From: Jean Fraser
To: Stowe, Barry
CC: (veroneau@jbbrown.com), Vincent Veroneau; JasonBlais
Date: 5/9/2014 3:50 PM
Subject: Re: FW: Exterior signage CY Portland

The purpose of this condition/plan is to help those looking for the restaurant, residences or hotel to know where to go - both in terms of entrances and in terms of which drive access to use and where to park.

Drawing file: Wayfindng / not final nor approved Signage Plan Marriot Portland 05-02-14.pdf

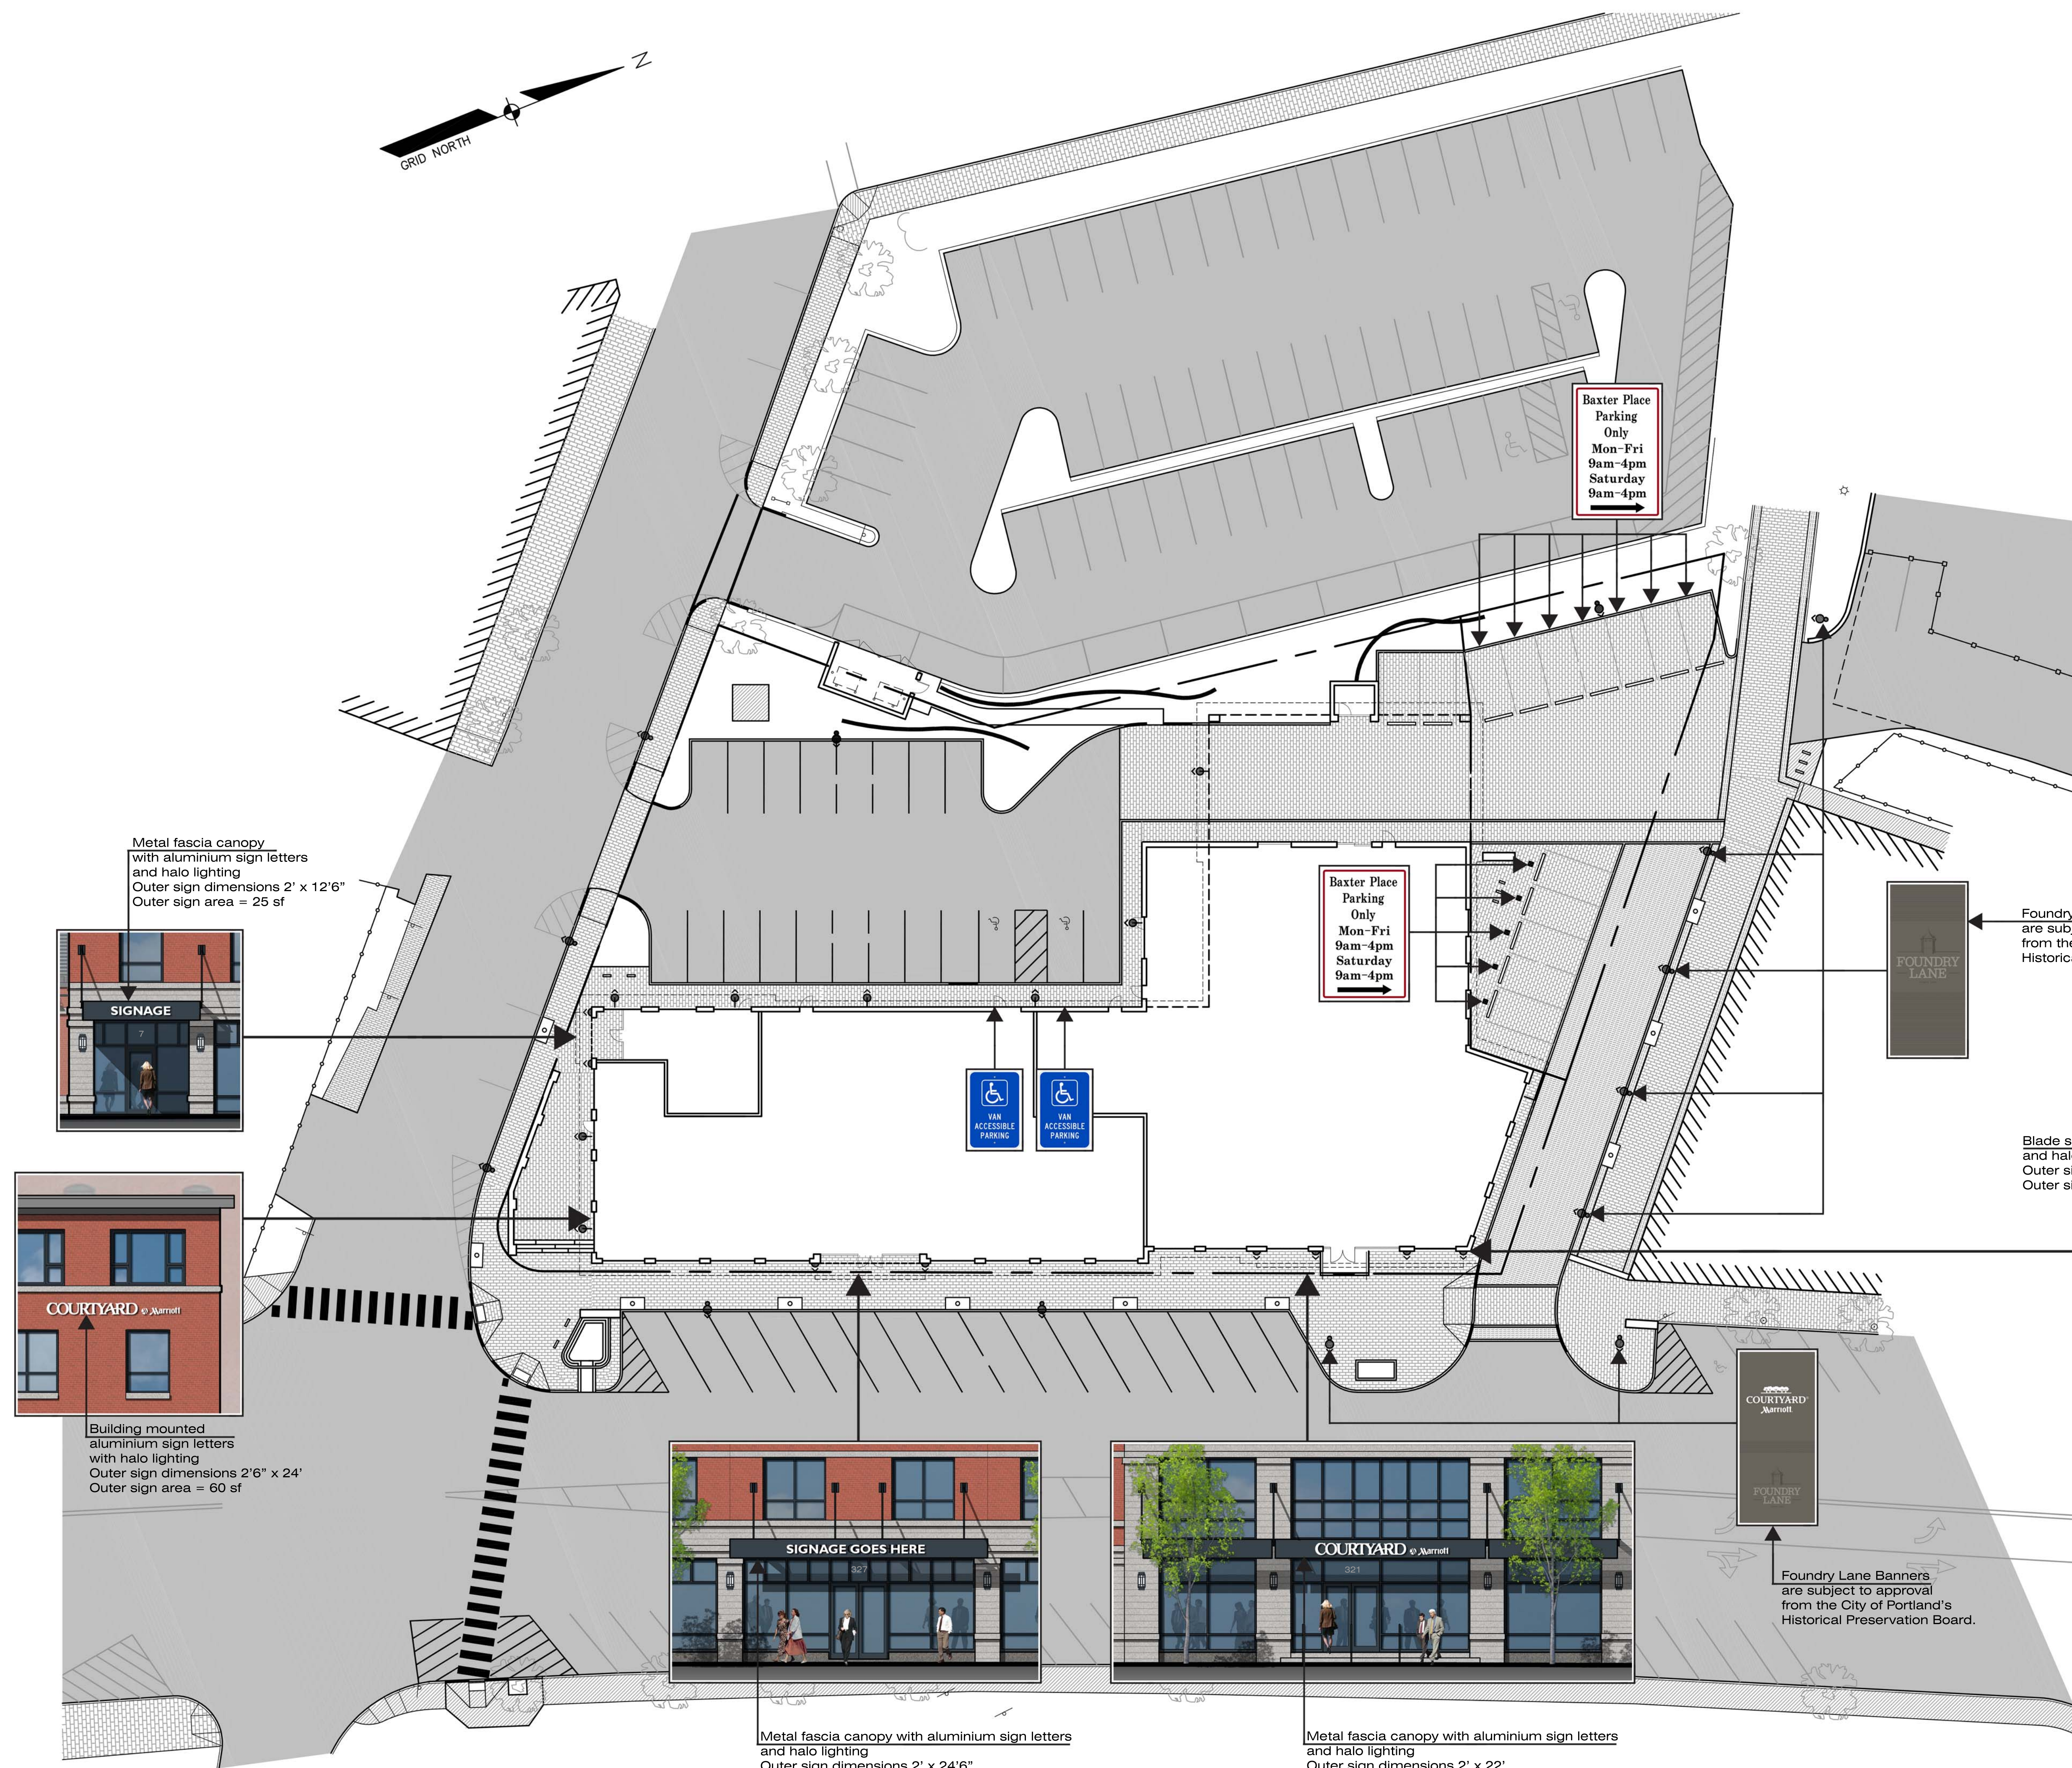
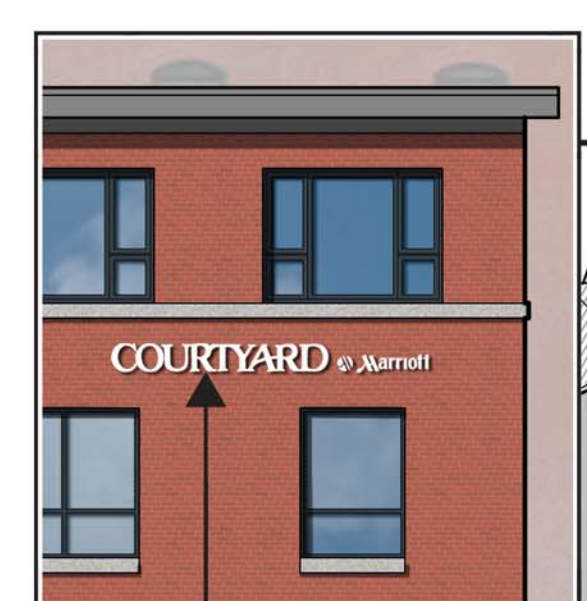
So we aren't just looking at where on the building it goes (though HP need to review that- has what you sent gone to Deb?) but what it says and the plan needs to include freestanding and other signs that direct the different users as I mentioned above.

I recall that during the TMP scoping meeting Tom Errico was concerned that people driving from the west would not know how to get to the port cochere (sp?) (and would turn into maple un-necessarily) and for cars leaving he wanted them to know which exit was best if they were going east /west (so to minimize left turners from Foundry onto Commercial).

So the plan needs to be more detailed and cover a greater range of signs...
